Application No: AB/101/21/HH
Site Address: 43 Torton Hill Road Arundel BN18 9HF
Description of works: Erection of two storey side/rear extension, porch to front with associated alterations to fenestration and drainage works.

Thank you for your internet representation made on 28th September 2021 which has been recorded as an objection with the comments as follows:

AB/101/21/HH - 43 Torton Hill Road Arundel

DRAWING TITLE
Floor plans as proposed

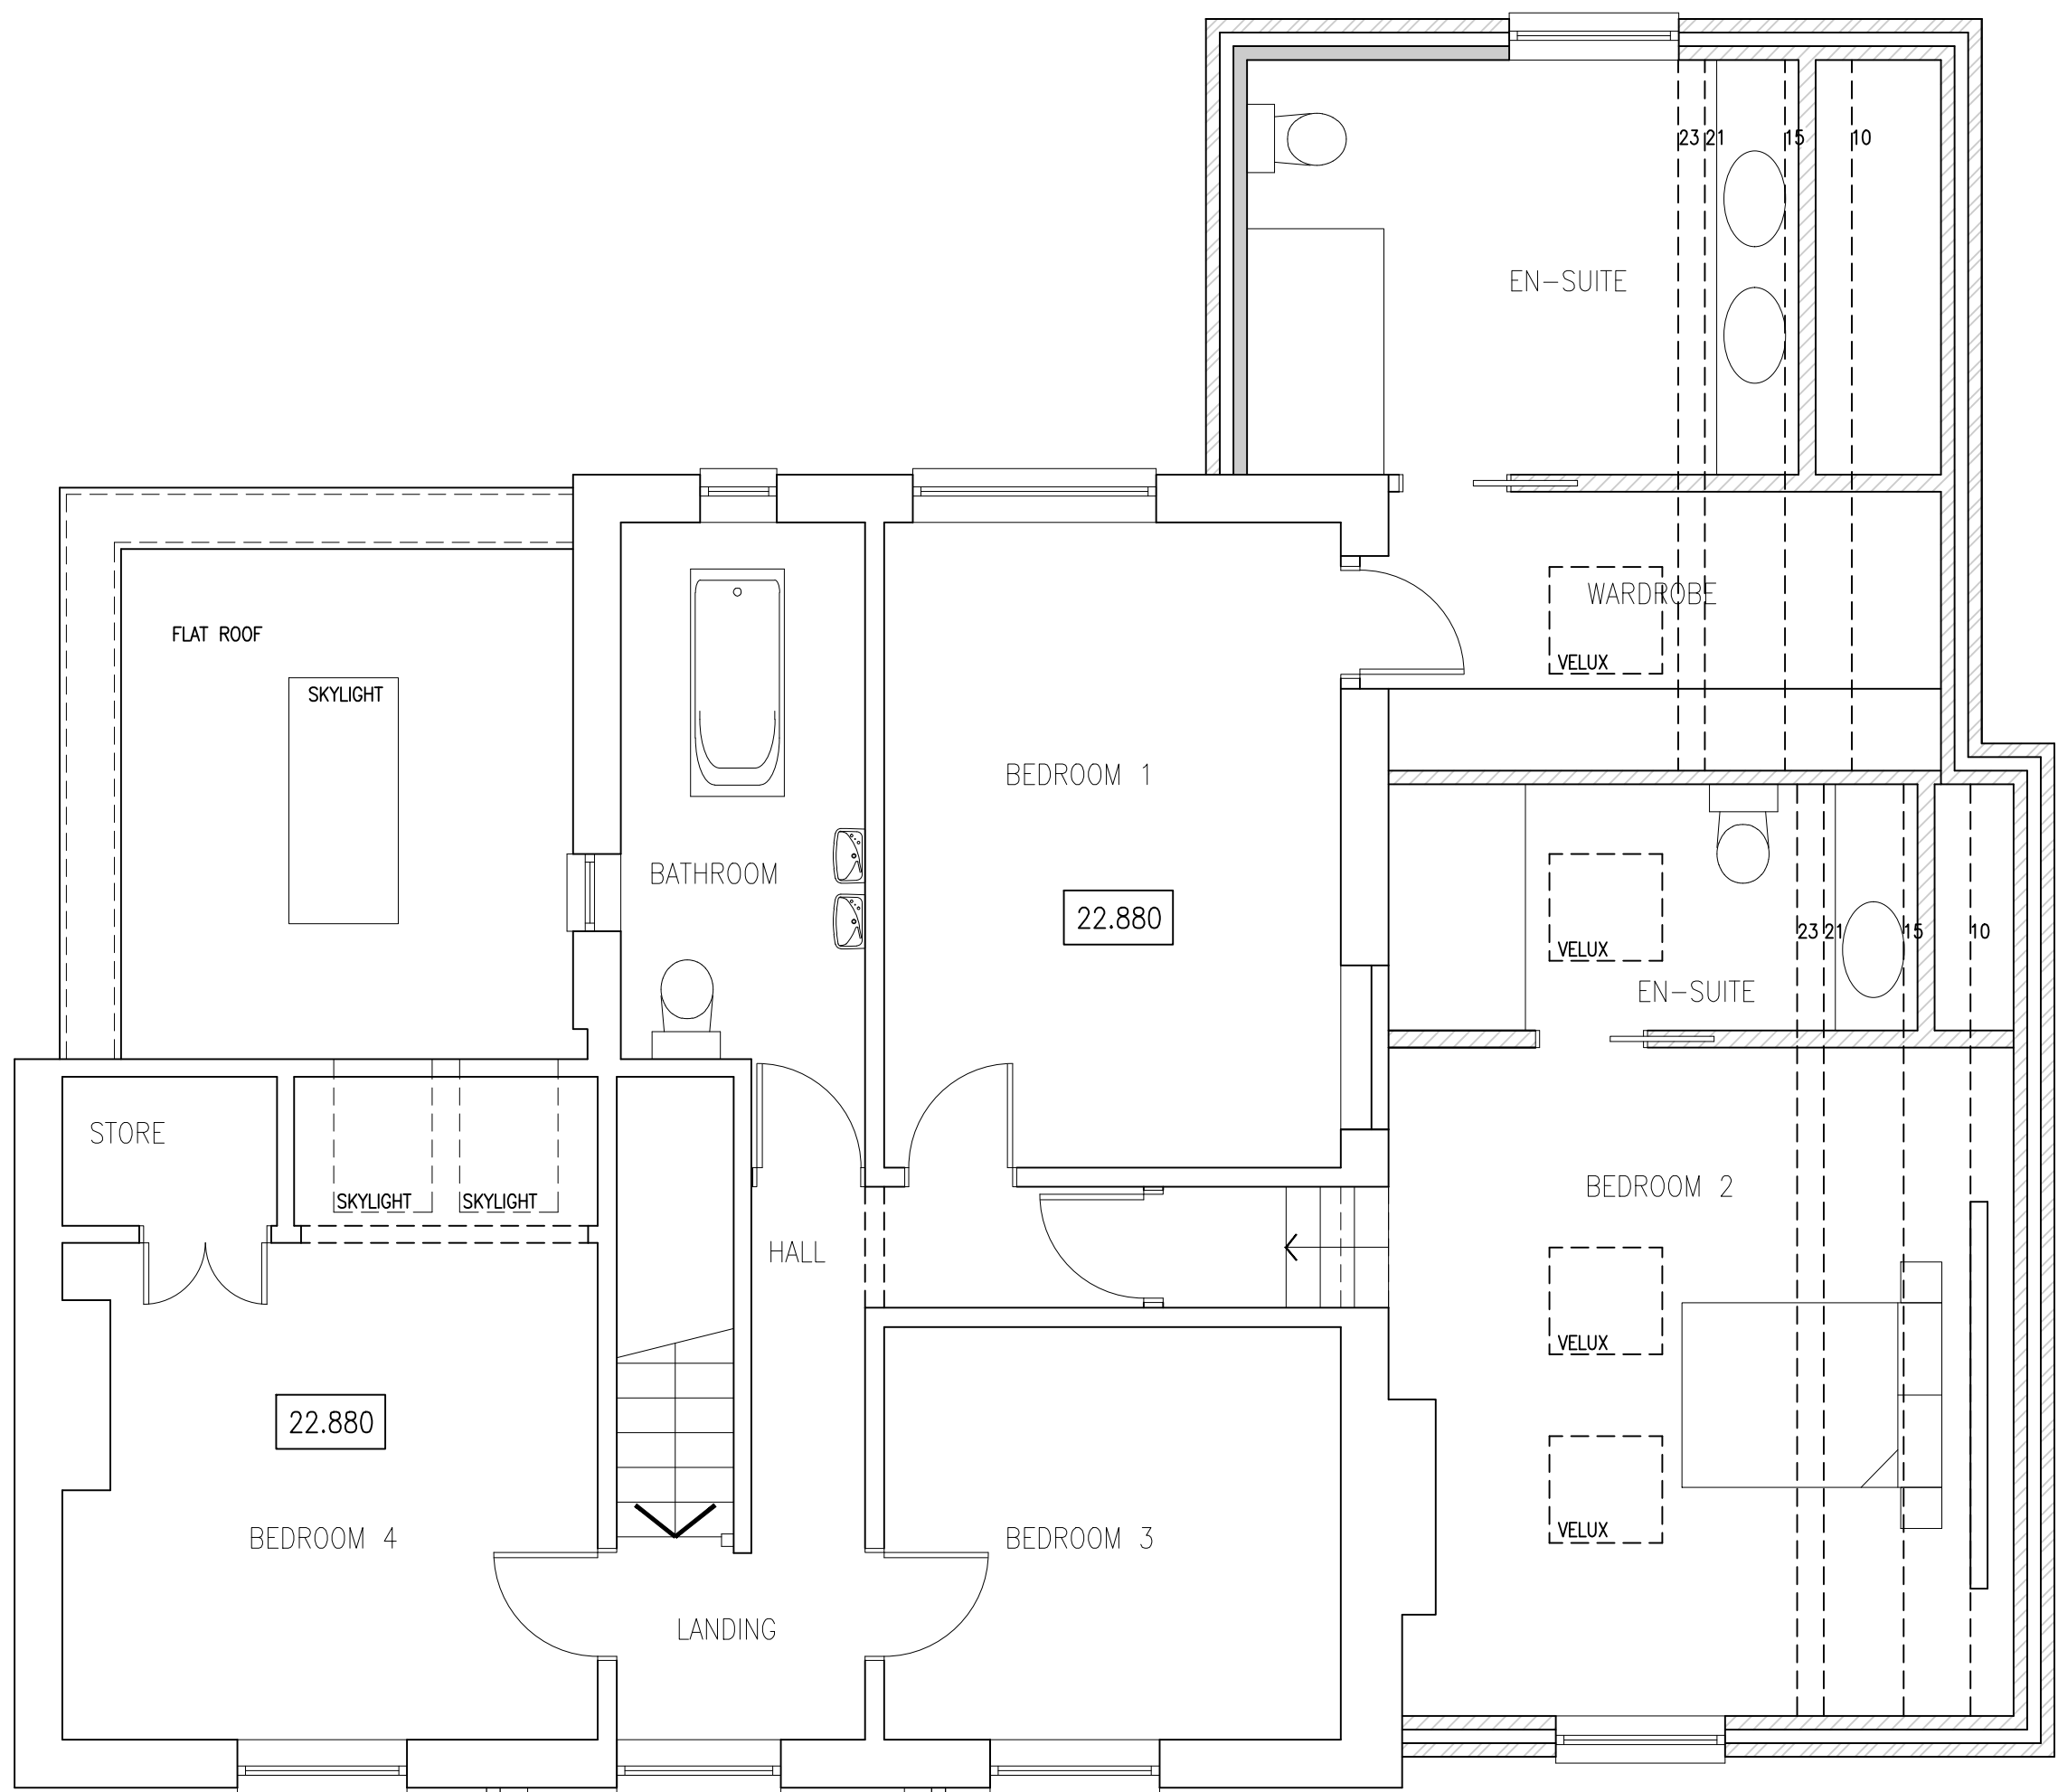
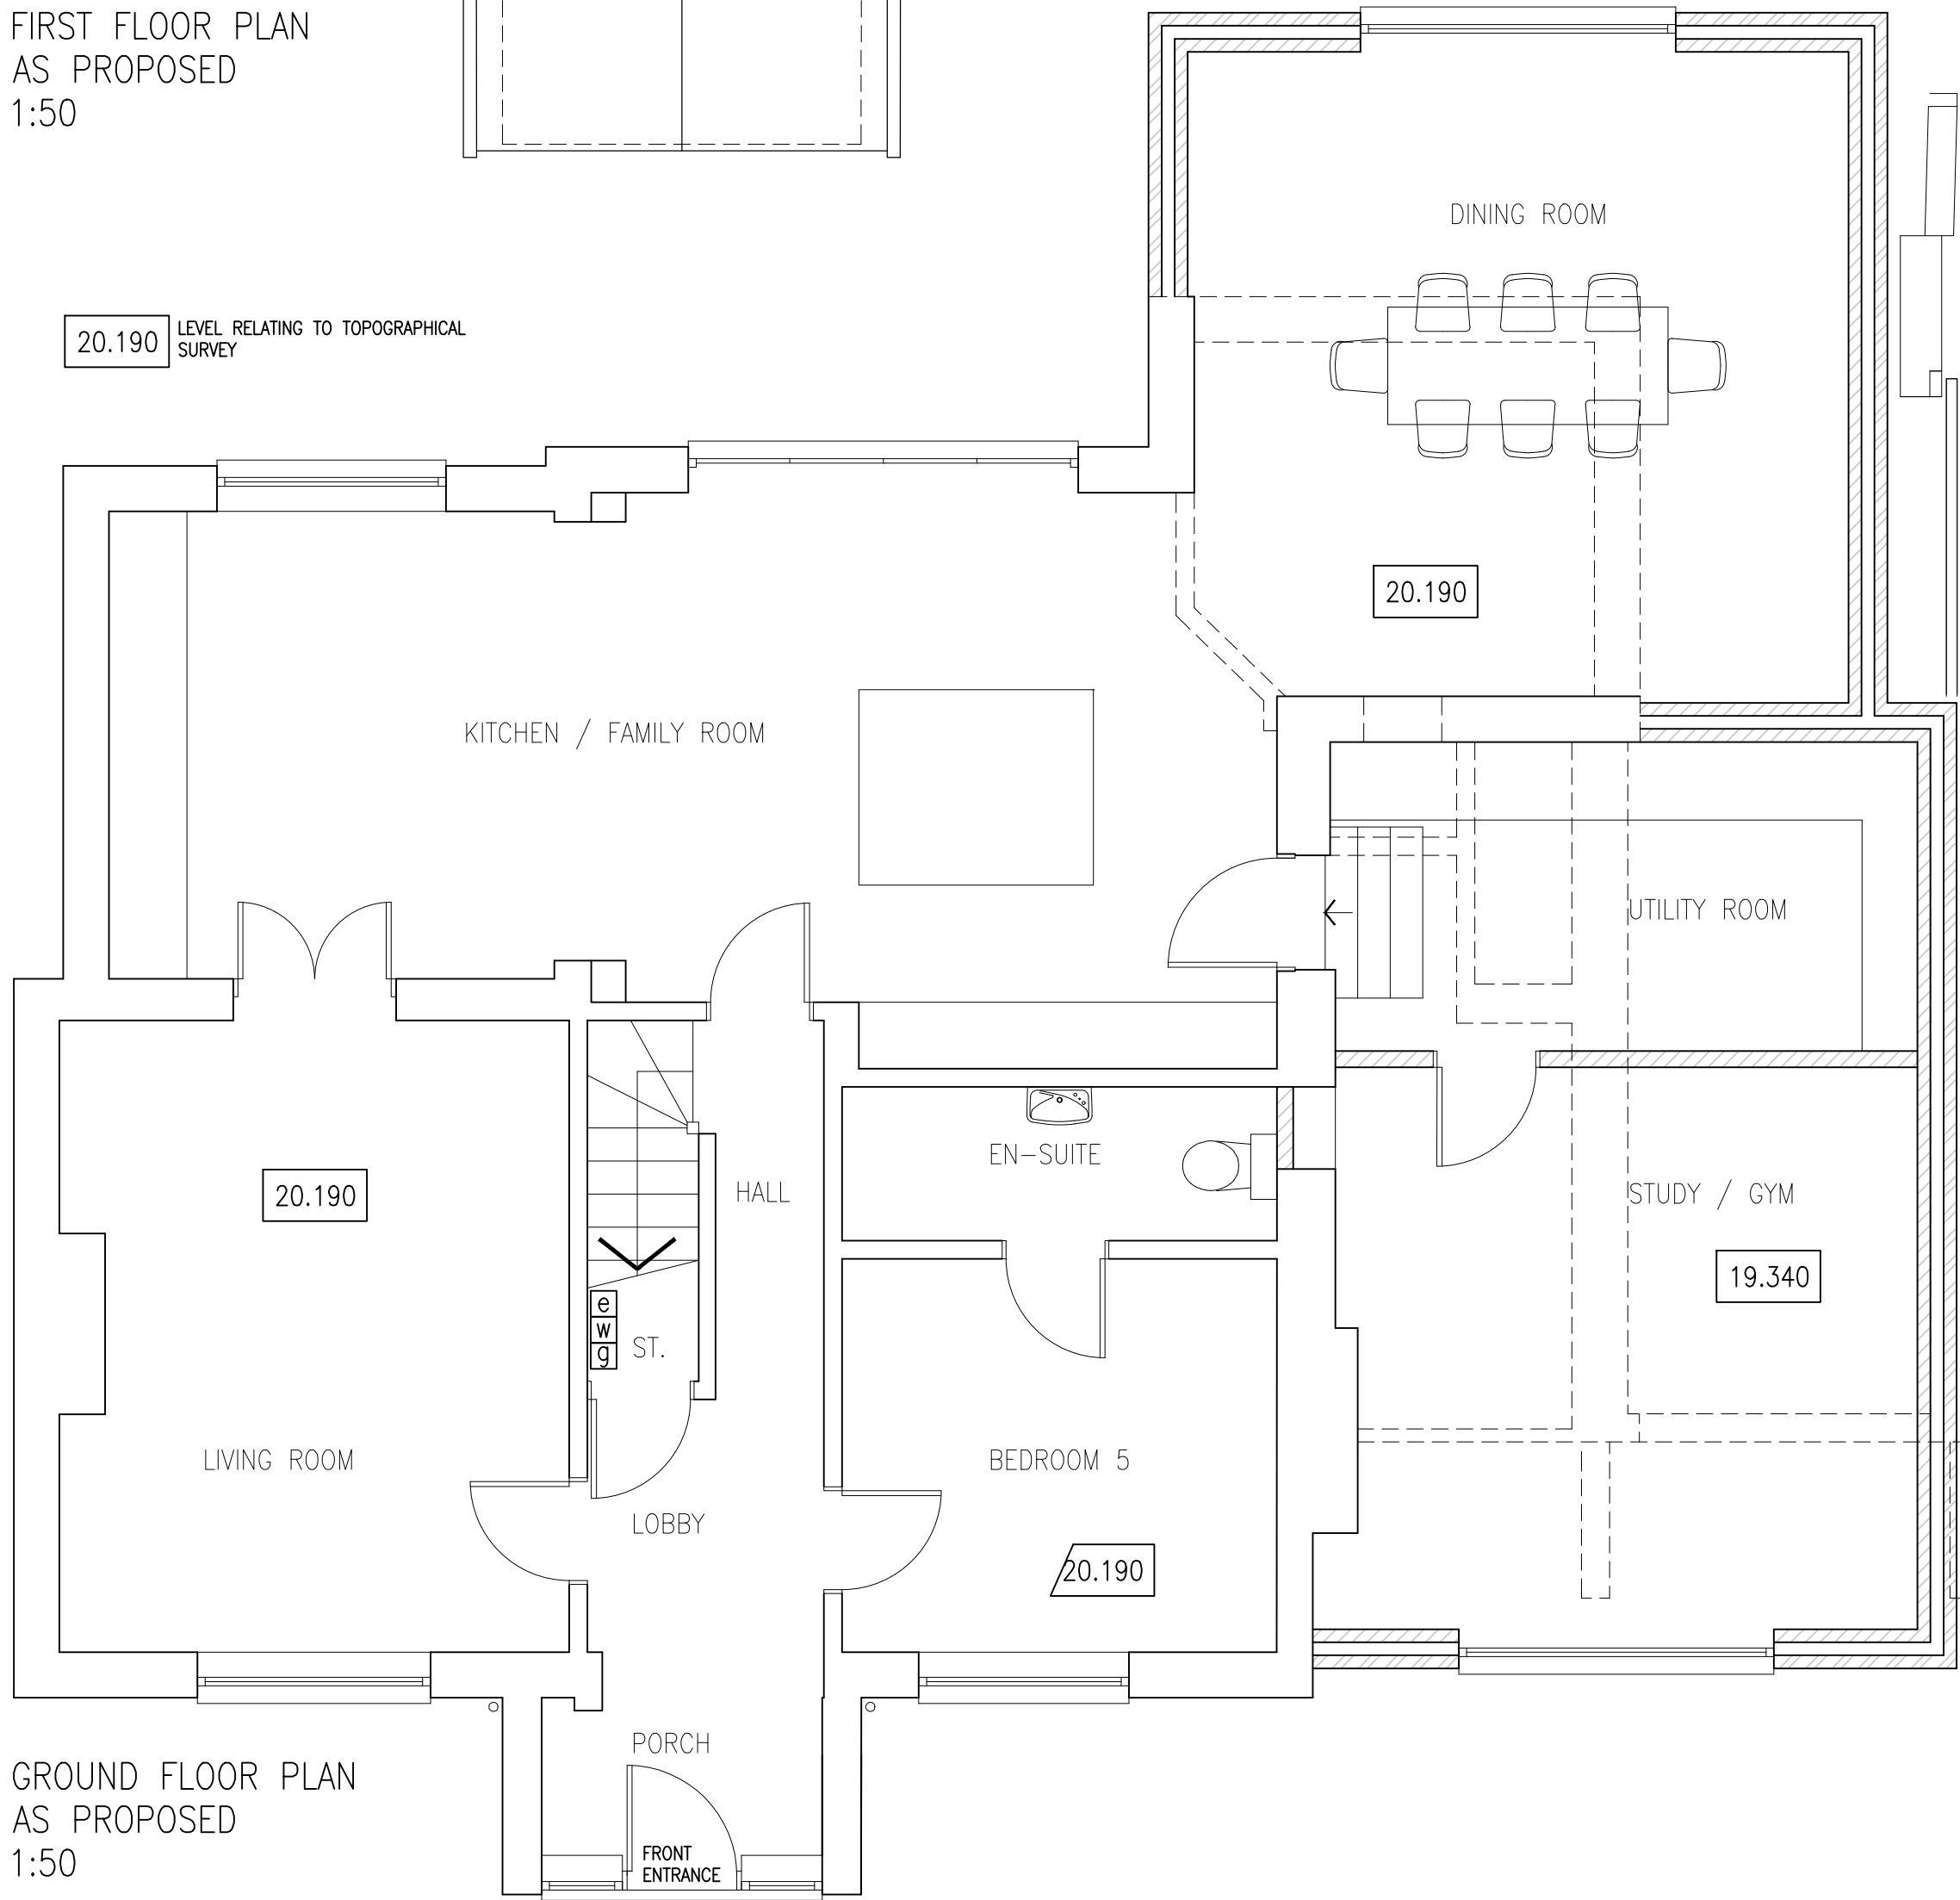
- Side Extension - Objection to the addition of Velux windows along the side extension as this will impact on the privacy of 45 Torton Hill Road. There are two Velux windows at 45 Torton Hill facing directly opposite the party wall for the proposed extension. Due to the proximity between the two houses this will compromise the privacy because four Velux windows on the proposed side elevation are of a size, height and angle that will allow direct visibility into the existing Velux windows (lavatory and family bathroom) of 45 Torton Hill, compromising privacy. In addition, windows will allow direct observation into both side and rear patio gardens removing the only private space in the garden for number 45.

- Side Extension - The intended works clearly encroach on the existing party wall shared by 43 Torton Hill and 45 Torton Hill. For the record, of concern to the owner of number 45 it seems that the party wall will be heightened and modified, terminating in a parapet at the gable. Therefore, as the owner of number 45 I would require provision to drain rainwater runoff without any encroachment on / or over the parapet for number 45. Runoff to be contained/ drained to existing points under Part G (2015) Building Regs.
